**KIRKLEES METROPOLITAN COUNCIL  
INVESTMENT & REGENERATION SERVICE**

**DELEGATED DECISION TO DETERMINE PLANNING APPLICATIONS**

Reference No:	<b>2024/62/90925/E</b>
Site Address:	114, Hunsworth Lane, Hunsworth, Cleckheaton, BD19 4DP
Description:	Raising of roof height and erection of extension to roof to create first floor living accommodation, erection of first floor rear extension and alterations
Recommending Officer:	Jennifer Booth

**DECISION – CONDITIONAL FULL PERMISSION**

**Project No:** D2314      **Scale:** as noted @ A1  
**Dwg No:** PL04        **Date:** Mar 2024  
**Revision:** -         **Drawn:** TEC

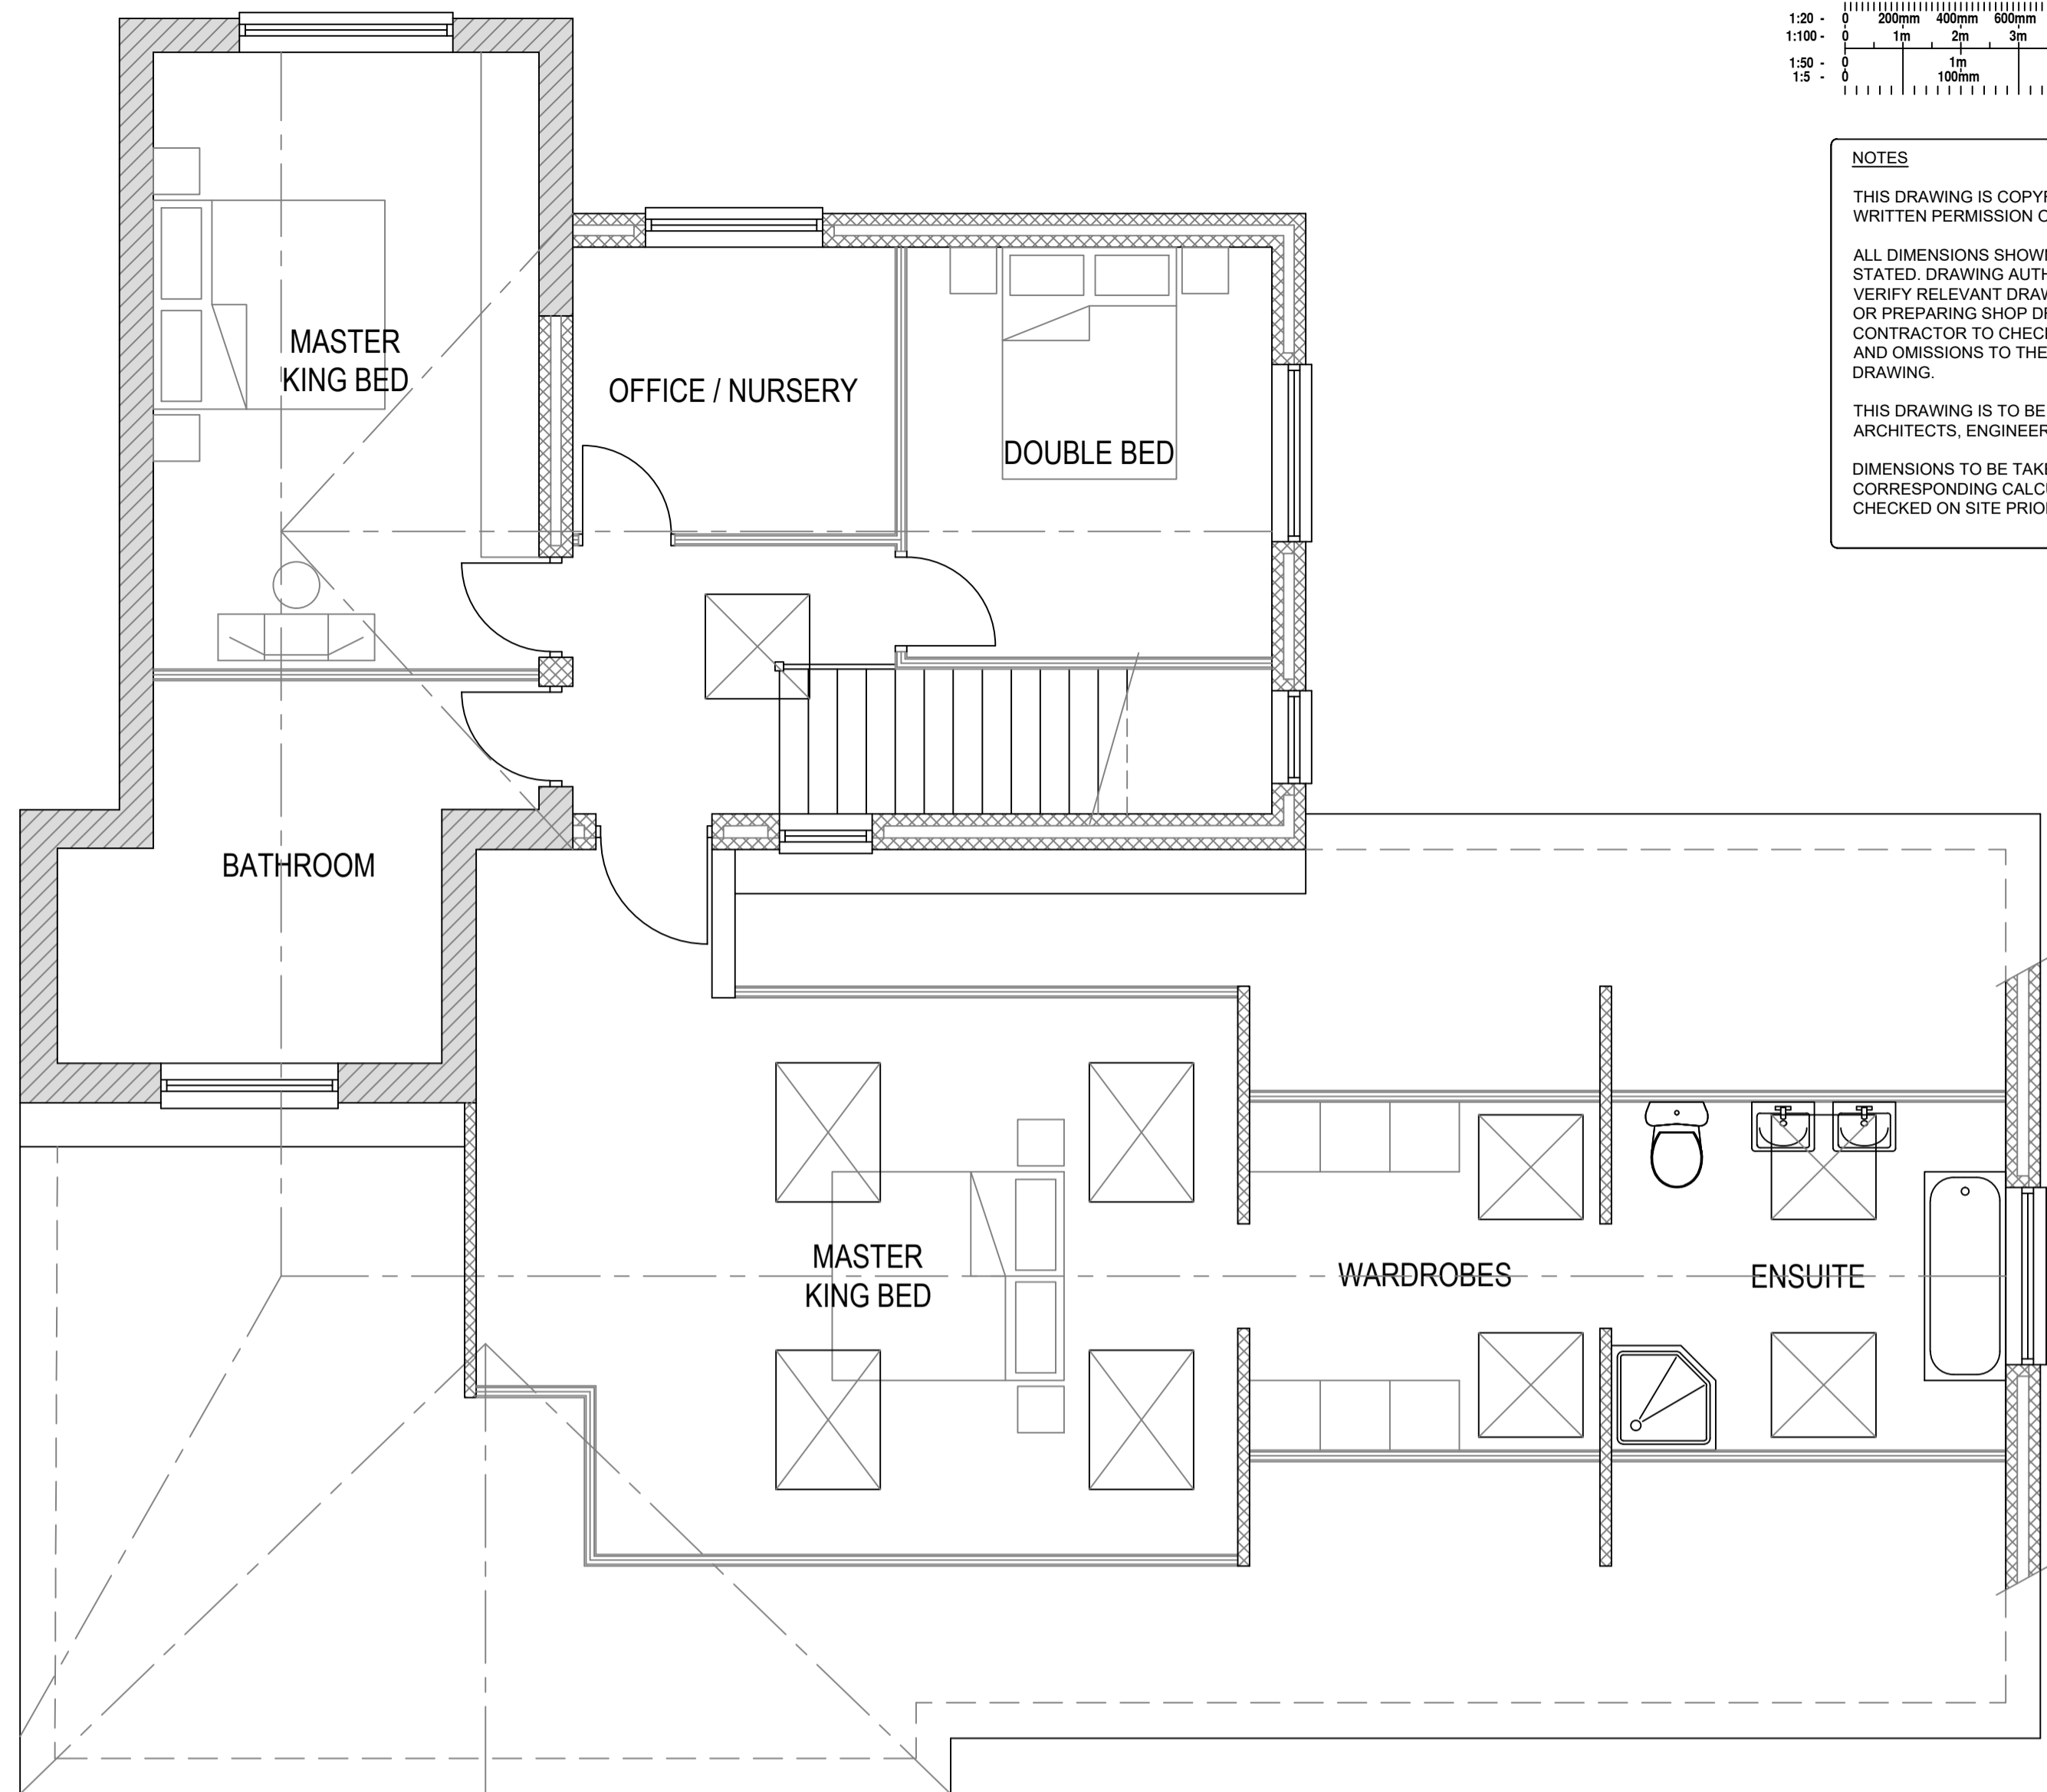
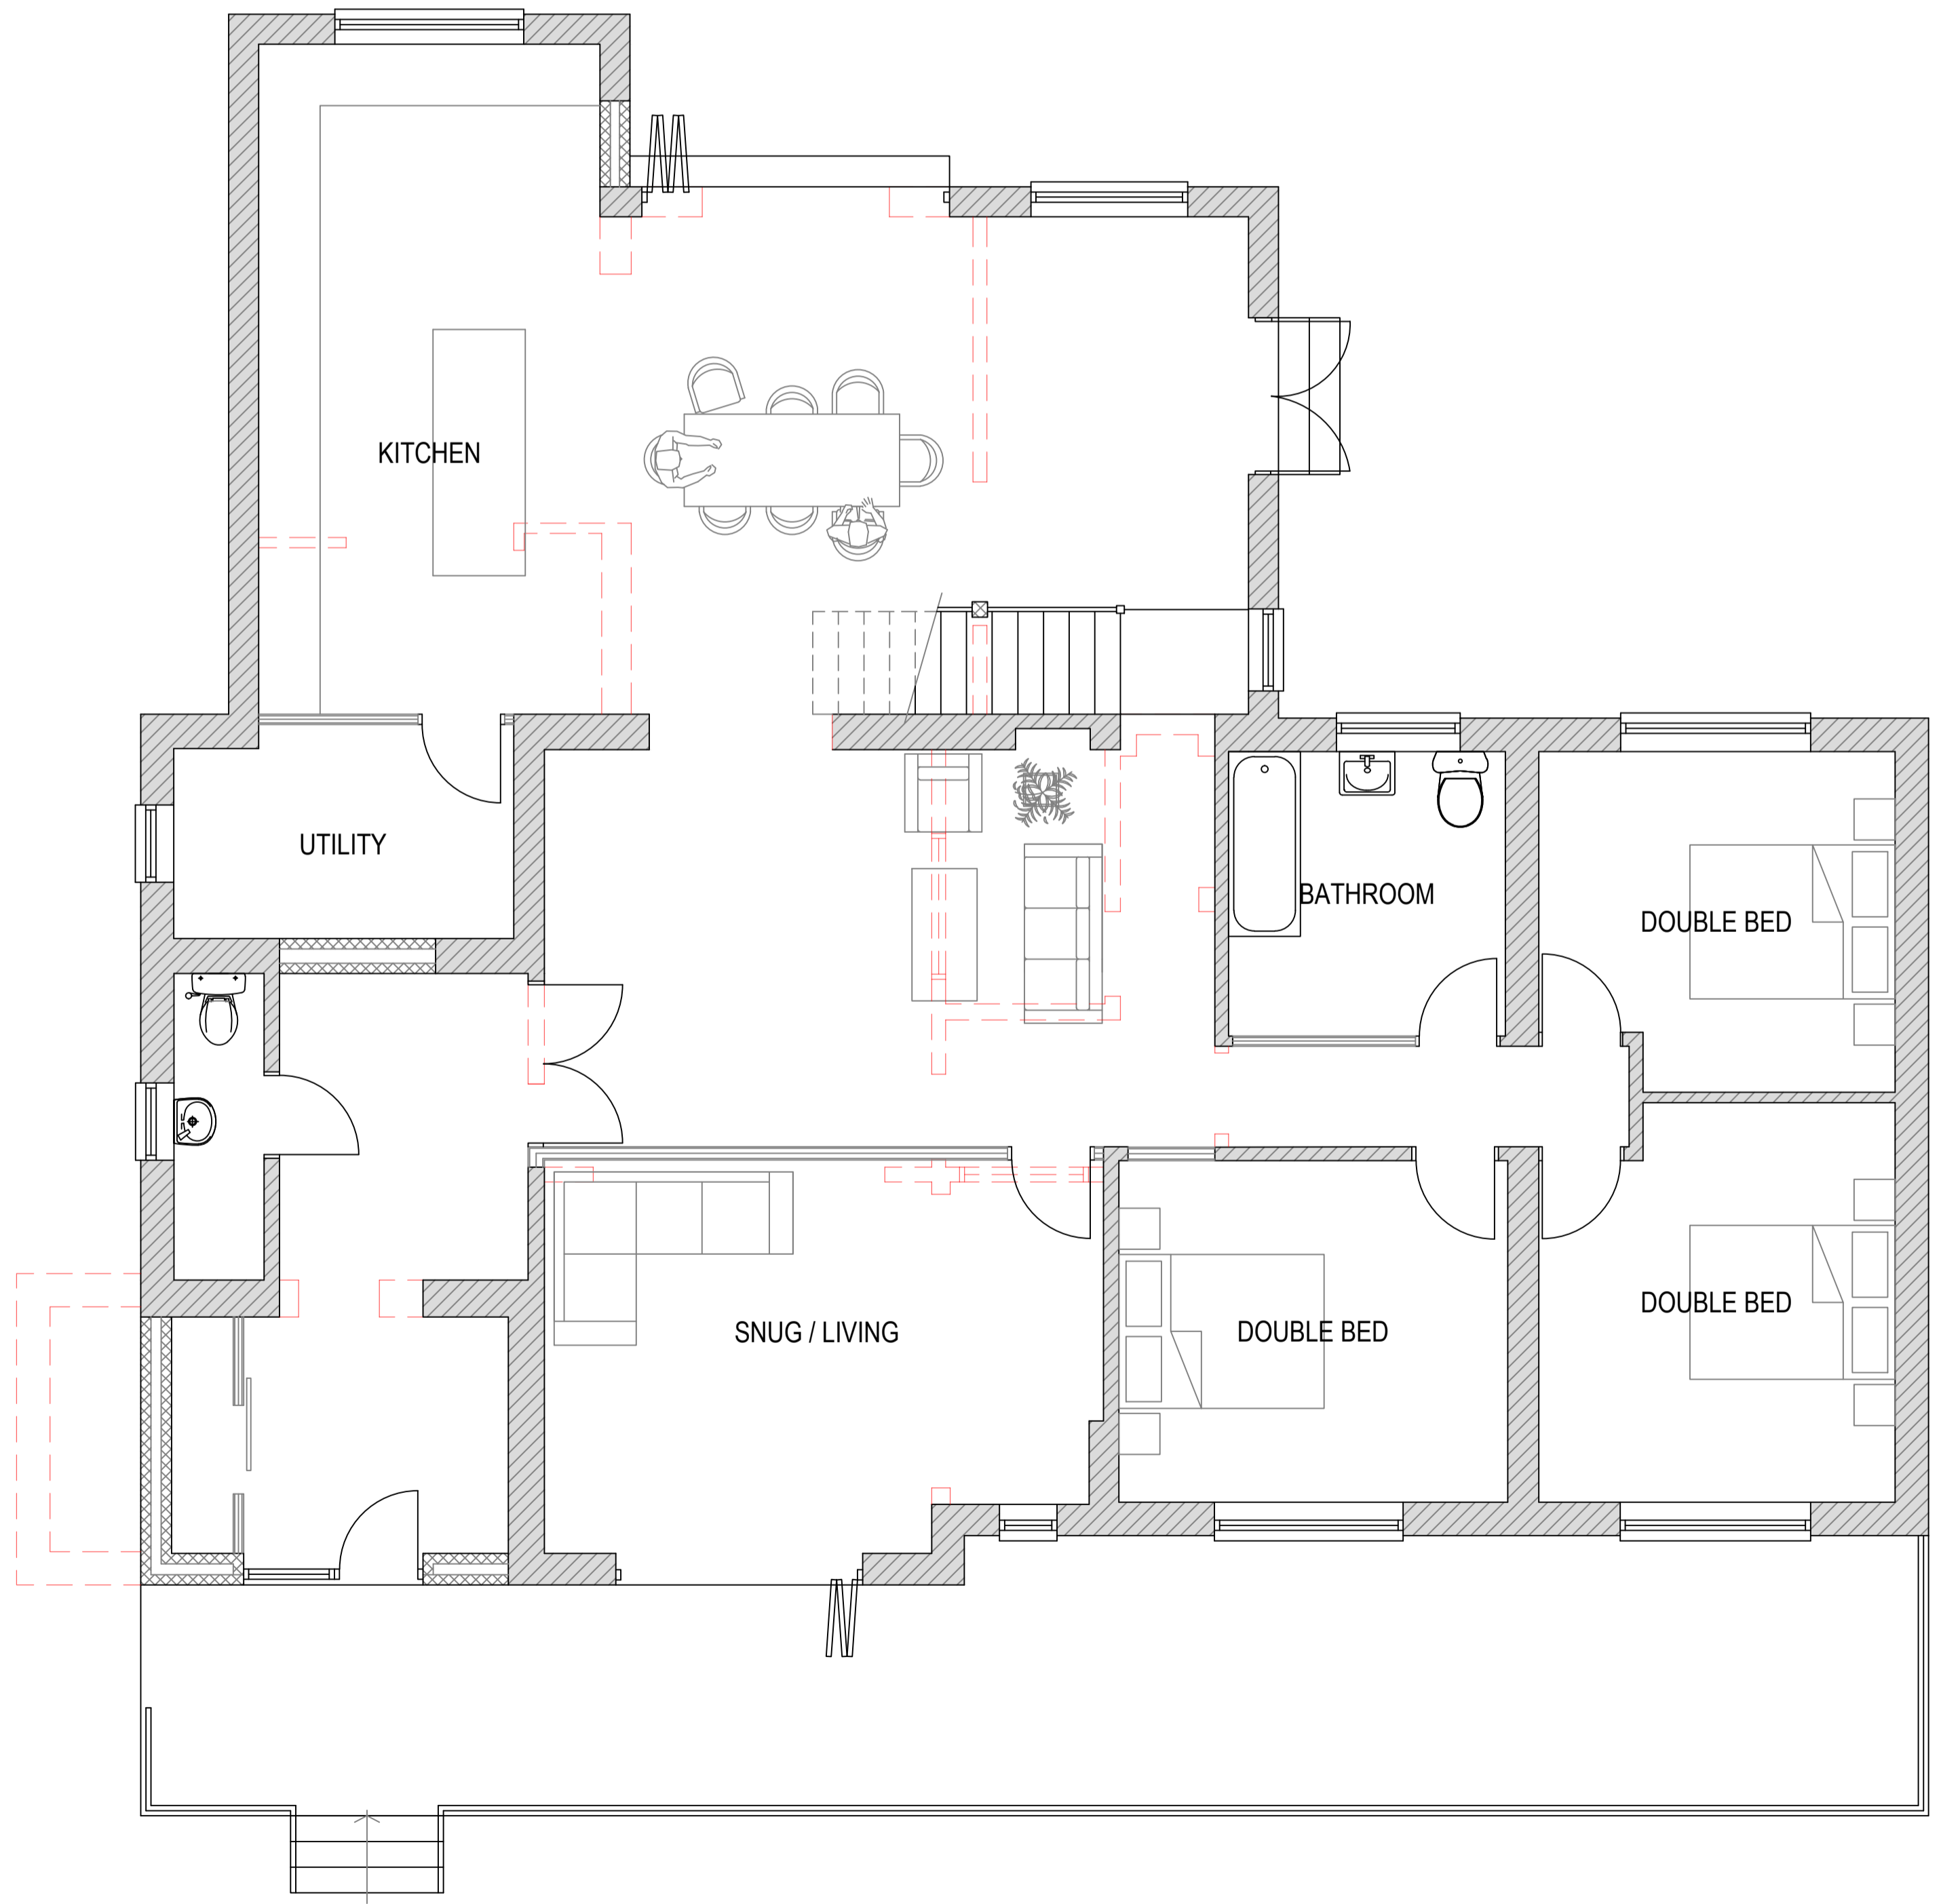
The footprint of the property would not be increased. The eaves would be carried across the front of the property at the same level, bringing the extension in line with the original. The hipped roof would be altered to a gable with an increase in height to match the apex of the two storey extension. The first floor rear extension would be built over the existing terrace.
